Deicorp Projects (Tallawong Station) Pty Ltd

Road Safety Audit Report Construction Stage

Tallawong Station Precinct South

May 2020

Traffic Control Plan

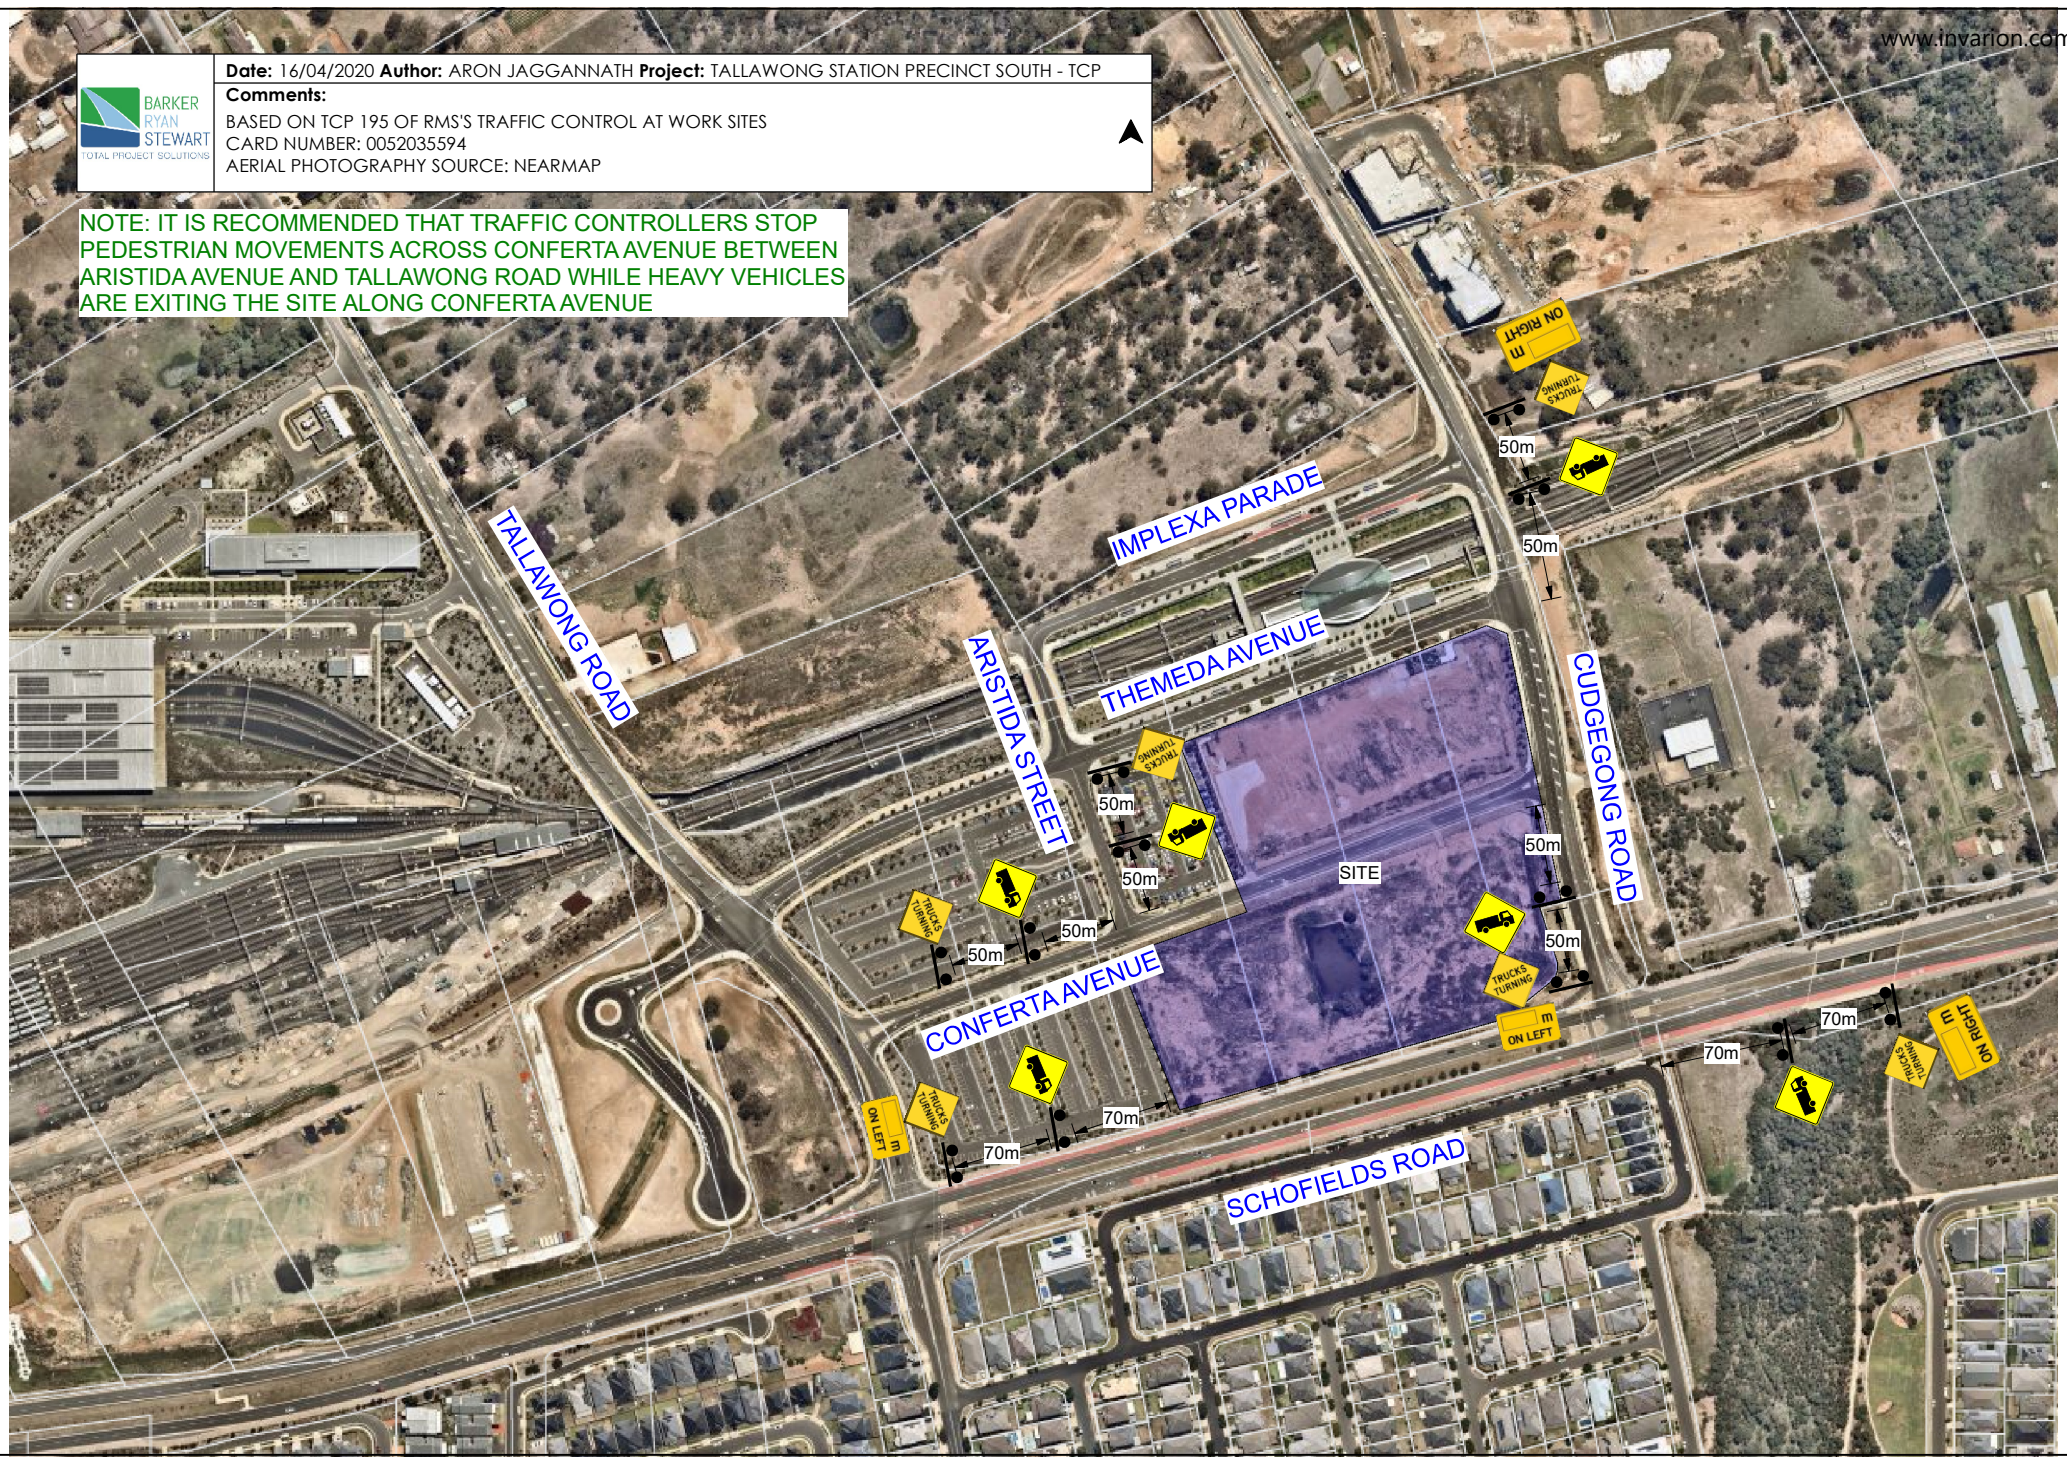
<p>3. Heavy vehicle movements at the Cudegong Road / Conferta Avenue intersection, the Tallawong Road / Conferta Avenue intersection and along Conferta Avenue will increase the risk to pedestrians crossing Conferta Avenue at these locations.</p>	<p>Appropriate warning signs should be installed on all roads surrounding the site to raise the awareness of pedestrians about heavy vehicle movements.</p> <p>In addition, it is recommended that traffic controllers stop pedestrian movements across Conferta Avenue between Aristada Street and Tallawong Road while heavy vehicles are exiting the site along Conferta Avenue.</p> <p>Note: All existing shared paths surrounding the site are required to remain accessible</p>	<p>Occasional / Serious = HIGH</p>

4. Construction vehicles using Themeda Avenue to enter and exit the site will create risks for pedestrians crossing Themeda Avenue to access the metro station and bus stops in Implexa Parade.	<p>Construction contractors should be provided with clear and concise instructions identifying that entry to and exit from the site will only be permitted via Conferta Avenue.</p> <p>In addition, the construction site entry at the Cudgegong Road / Conferta Avenue intersection should be clearly signposted.</p>	Occasional / Serious = HIGH		
<p>5. Construction vehicles, particularly concrete trucks waiting to access the site may obstruct traffic flow and / or restrict sight lines in Cudgegong Road, thereby increasing the risk of crashes.</p> <p>The likely low travel speeds in this area will reduce the severity of potential crashes.</p>	The Construction Management Plan for the site should include procedures and processes to safely and efficiently manage the arrival and departure of construction vehicles during concrete pours.	Occasional / Minor = MEDIUM

NOTE: IT IS RECOMMENDED THAT TRAFFIC CONTROLLERS STOP PEDESTRIAN MOVEMENTS ACROSS CONFERTA AVENUE BETWEEN ARISTIDA AVENUE AND TALLAWONG ROAD WHILE HEAVY VEHICLES ARE EXITING THE SITE ALONG CONFERTA AVENUE
